Project Address: Proposed Development for 94 Dwelling Units at lands 150m North of the N55, Lissywollen, TD, Athlone, Co Westmeath.

Project Reference: 127

Response to submissions received from Uisce Éireann

Re: Part 10 Planning Application – Proposed Development of 94 Dwelling Units at Lands 150m North of the N55, Lissywollen TD., Athlone, Co. Westmeath

Scales	1:1000	Page Size	A1	Status	PLANNING	
Drawn by	AS	Date	NOVEMBER 2025	Checked	CD	
P:\027\23188 - Westworth Cdd - Housing Scheme - Certainty At Home Drawings\3.A - PLANNING\23188-3031-3043.dwg						
Project No.	23188-3031				Revision	PL2

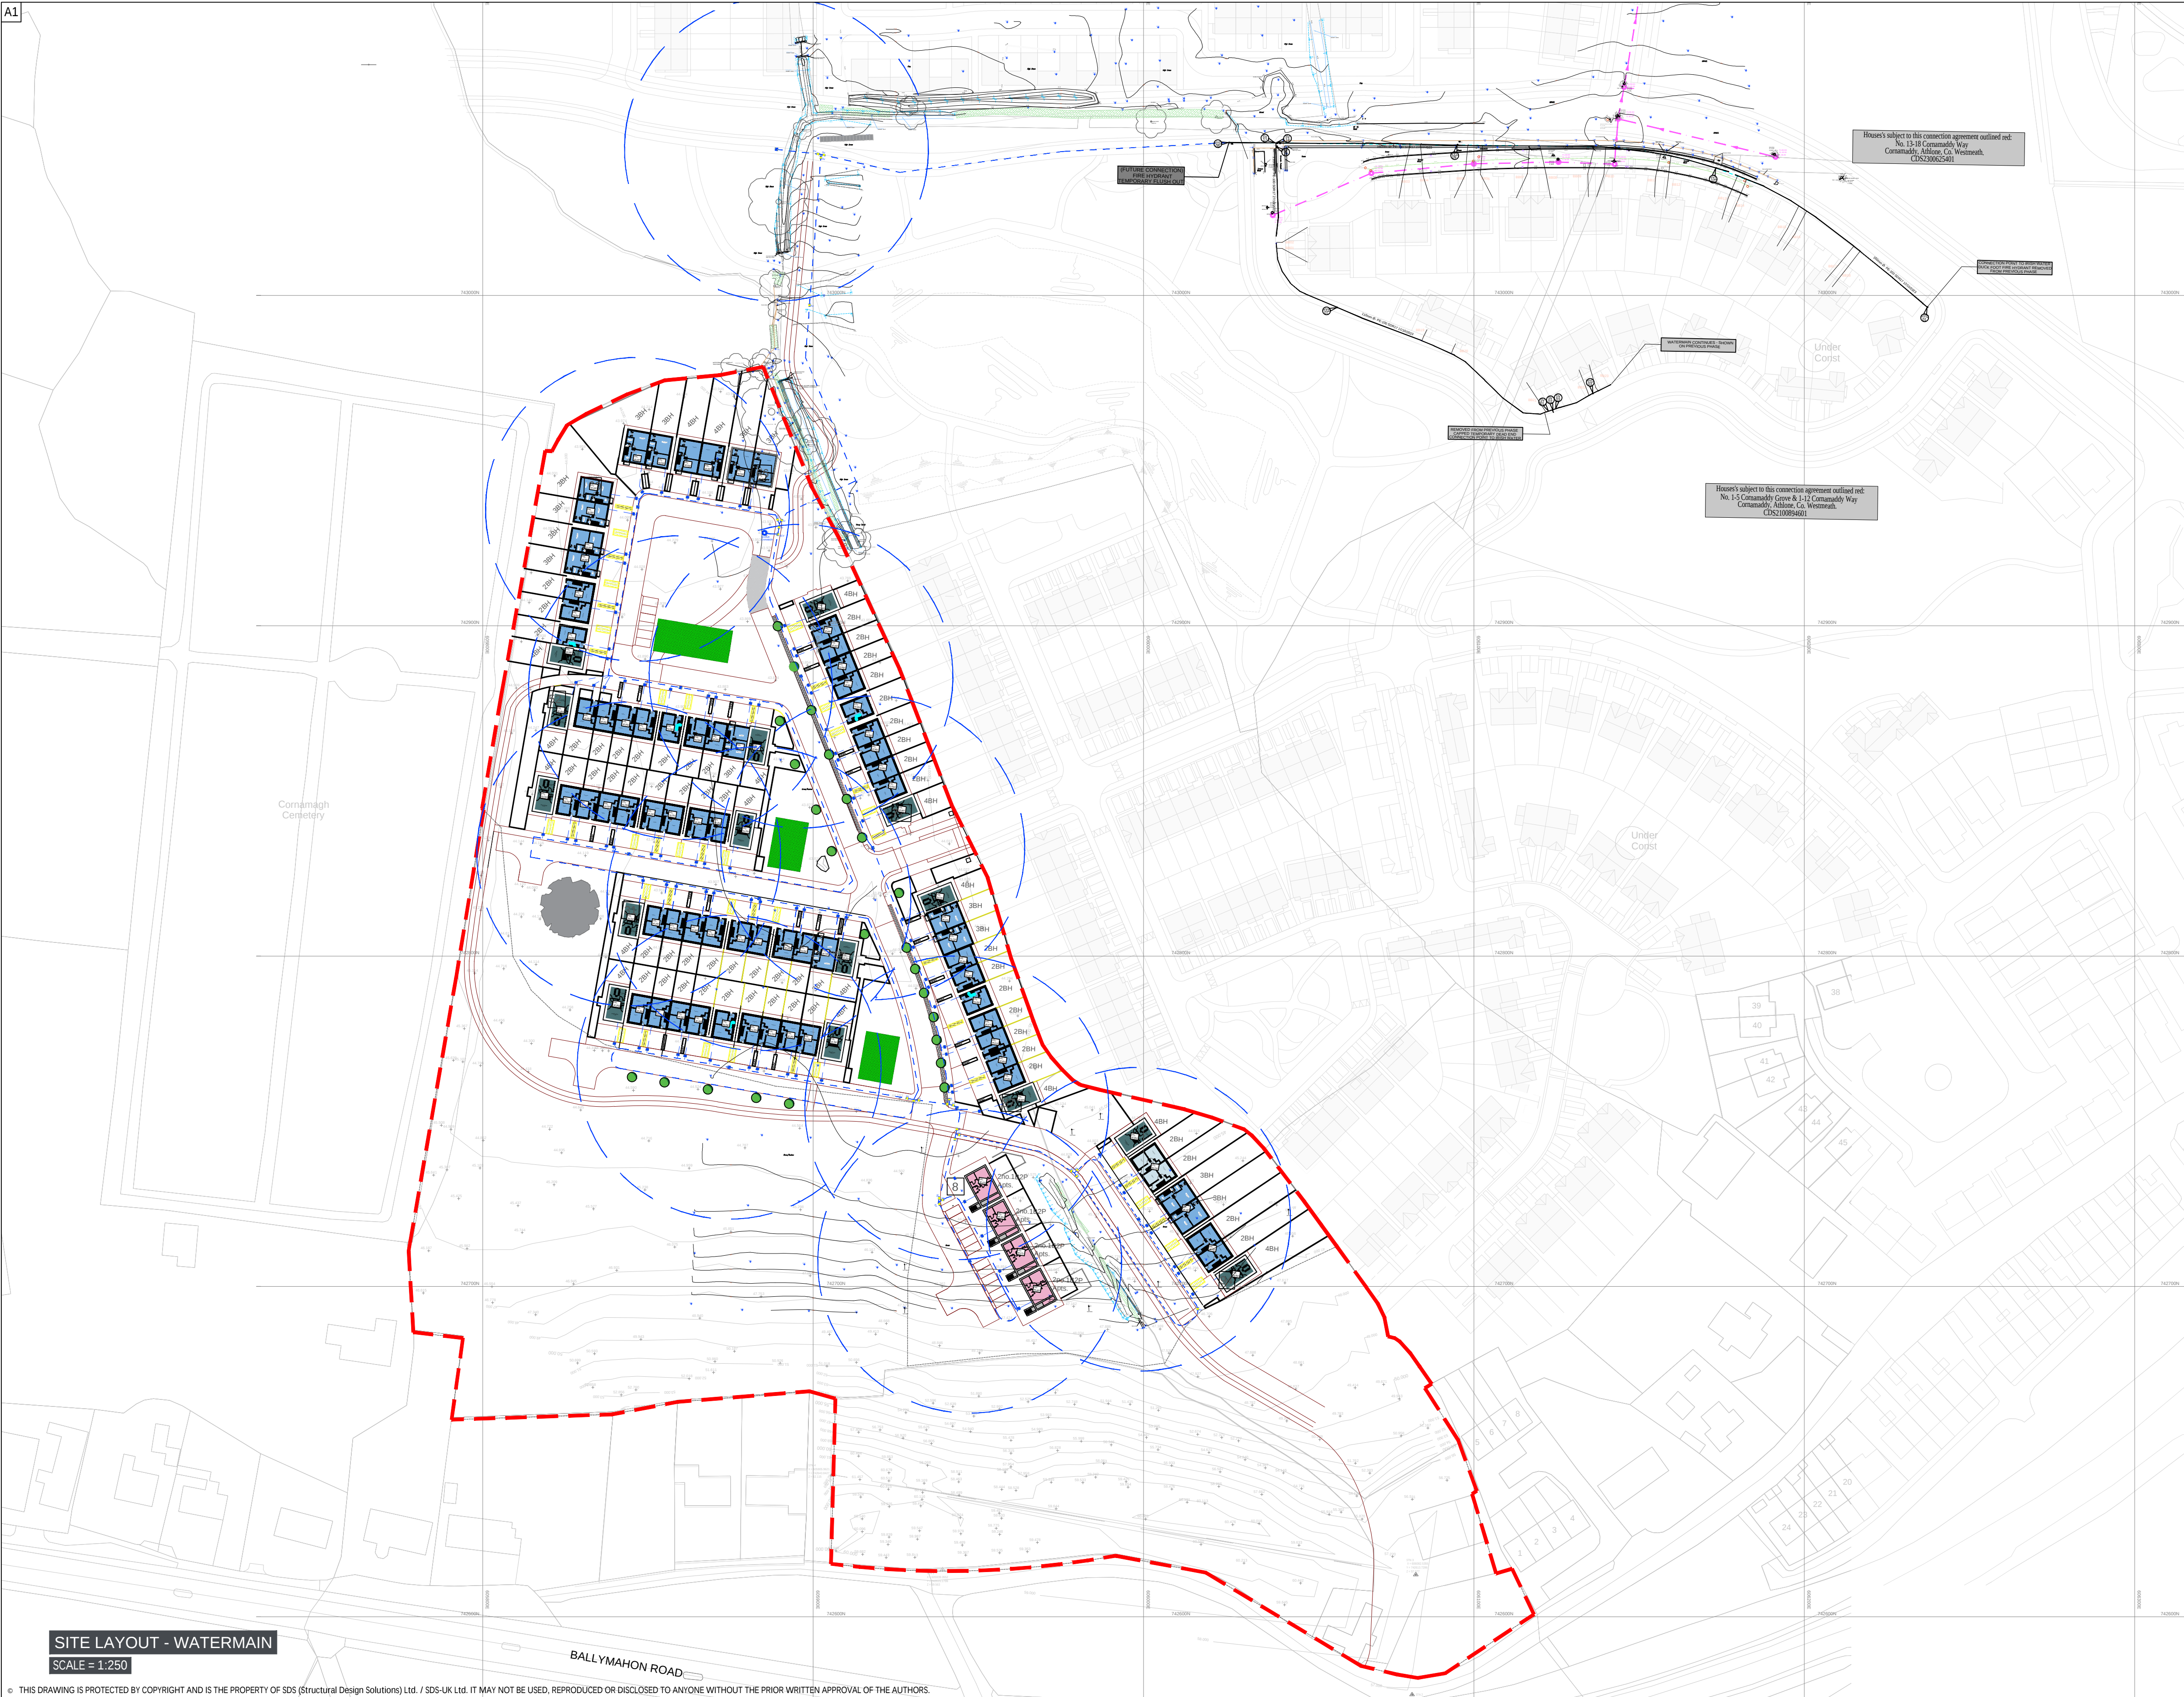
2. The applicant / developer shall fund the extension of the potable water network required to provide a connection to the proposed development - approximately 210 metres of 150mm diameter watermain - in accordance with the particulars of the Connection Agreement.

Westmeath county Council are committed to fund the extension of the potable water network required to provide a connection to the proposed development - approximately 210 metres of 150mm diameter watermain - in accordance with the particulars of the Connection Agreement.

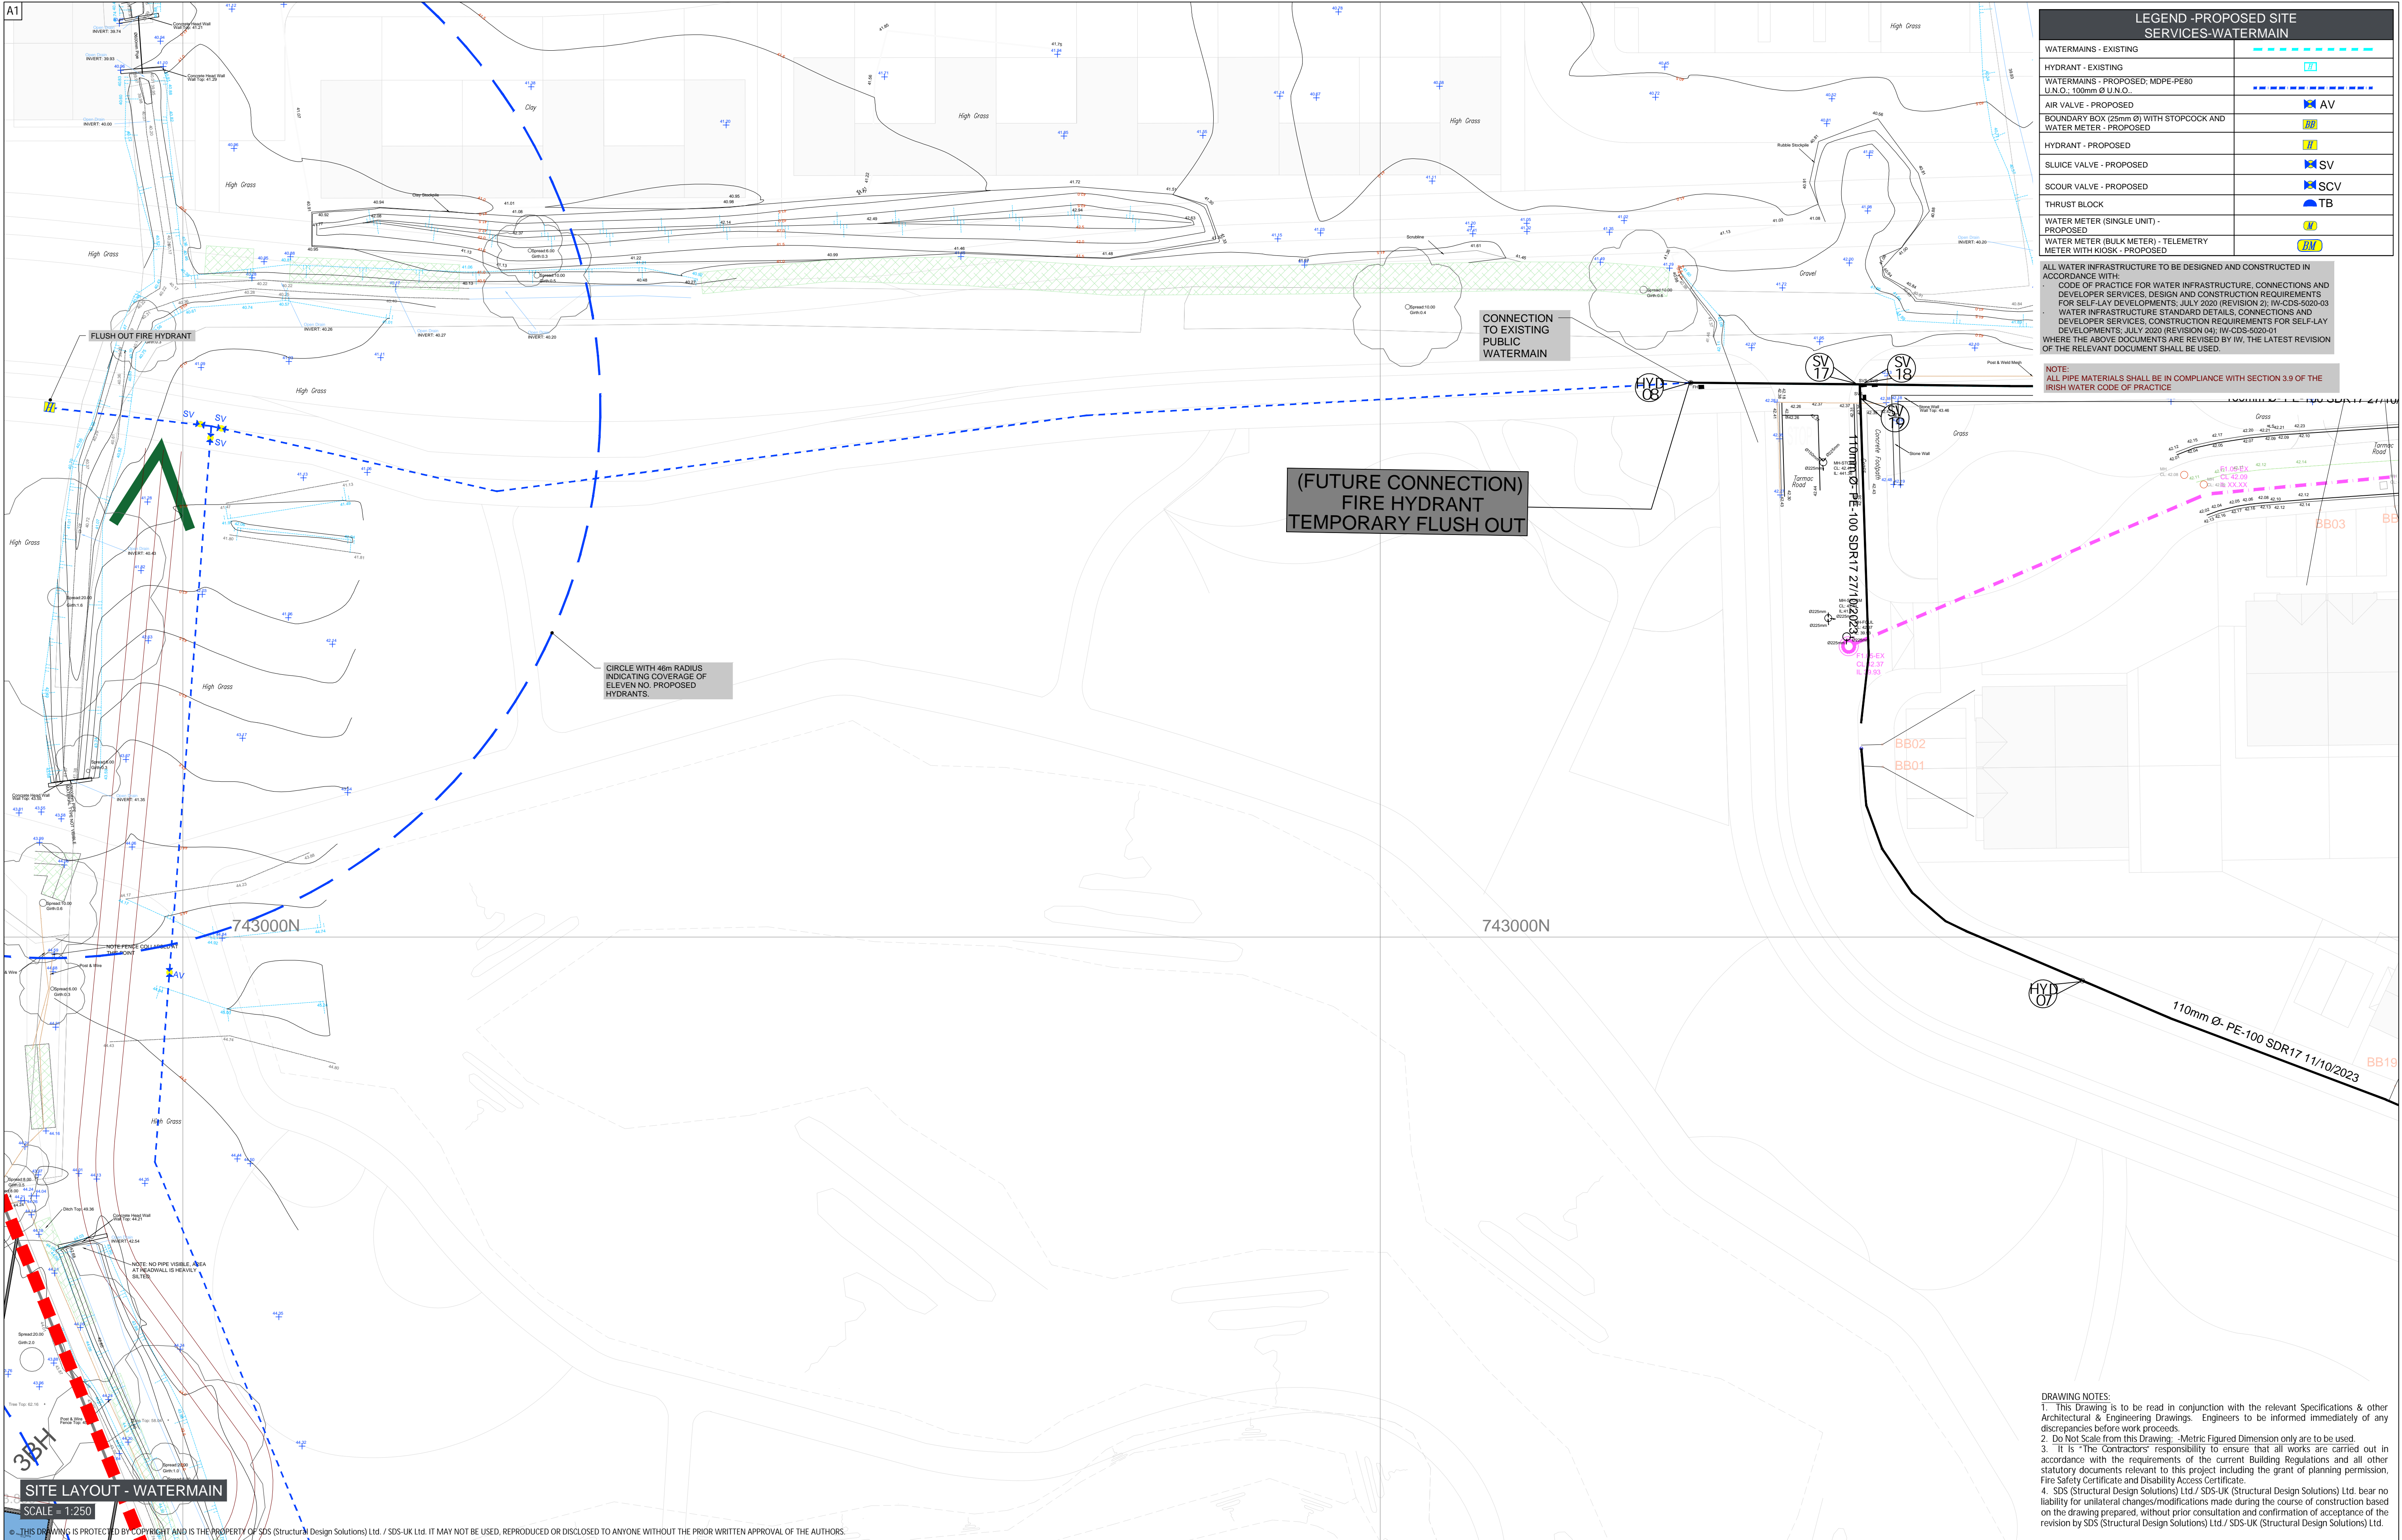
3. The Uisce Éireann owned foul network is located in private lands to the Northwest of the proposed development site. Prior to commencement, the applicant shall secure permission from the private land owner to allow for the connection works to be undertaken by Uisce Éireann contractors.

4. The applicant shall obtain any permissions/consents and wayleaves for the connection pipework within third party lands.

Westmeath county Council are committed to secure permission from the private landowner to allow for the connection works to be undertaken by Uisce Éireann contractors.

Westmeath county Council are committed to obtaining any permissions/consents and wayleaves for the connection pipework within third party lands.
